PLANNING CONSULTATION RESPONSE

Application No	2026/0610
Proposal	Install of front boundary wall and gates to dwelling
Address	11A School Street, Great Houghton, Barnsley, S70 0AE
Date of Consultation Reply	07/09/26
Consultee	Highways DC

11a SCHOOL STREET BOUNDARY WALL AND GATES

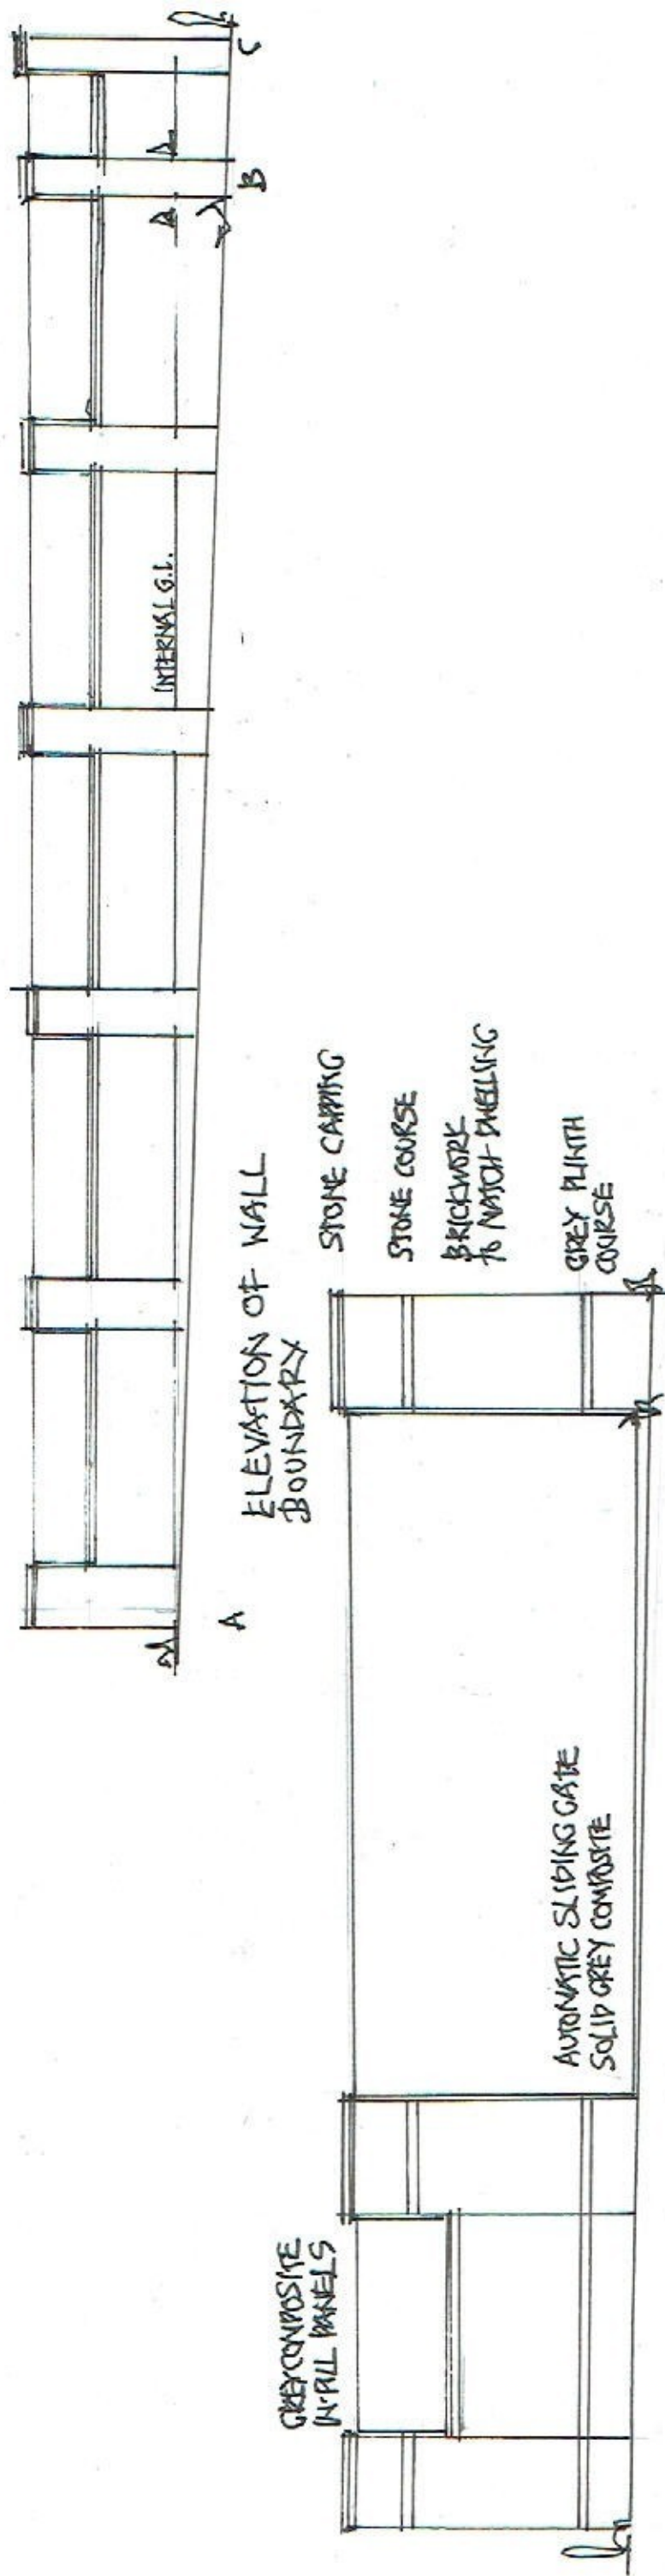
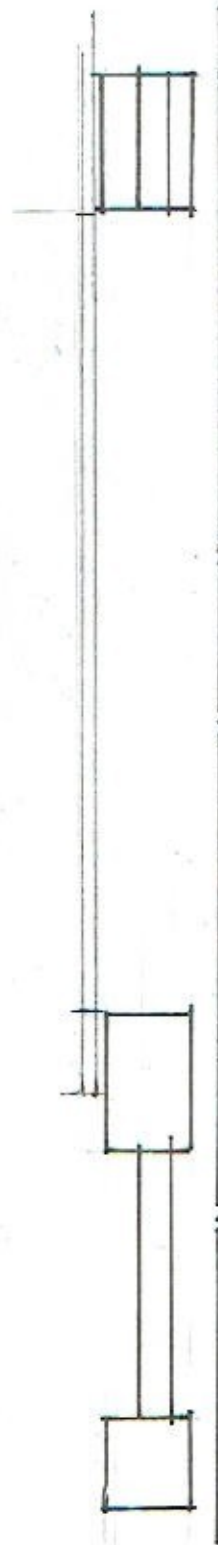
Highways DC officers would have no objection to the scheme so long as vehicular and pedestrian intervisibilities are maintained and that the conditions attached to the existing permission when the dwelling was built are adhered to. The 2020/0750 approval included the following conditions:

8. Sightlines, having the dimensions 2m x 2m, shall be safeguarded at the junction of the access/driveway with School Street, such that there is no obstruction to visibility at a height exceeding 1.05m above the nearside channel level of the adjacent highway.

9. Boundary treatments to the front of the development shall be set at a height no greater than 1m above the level of the nearside channel line of the public highway.

It appears likely that the proposed gate and wall are significantly higher than the 1m limit specified in condition 9 of the previous approval. As such, HDC officers would ask that the scheme conforms to the two above conditions with the pedestrian sightlines described in condition 8 demonstrated on a plan.
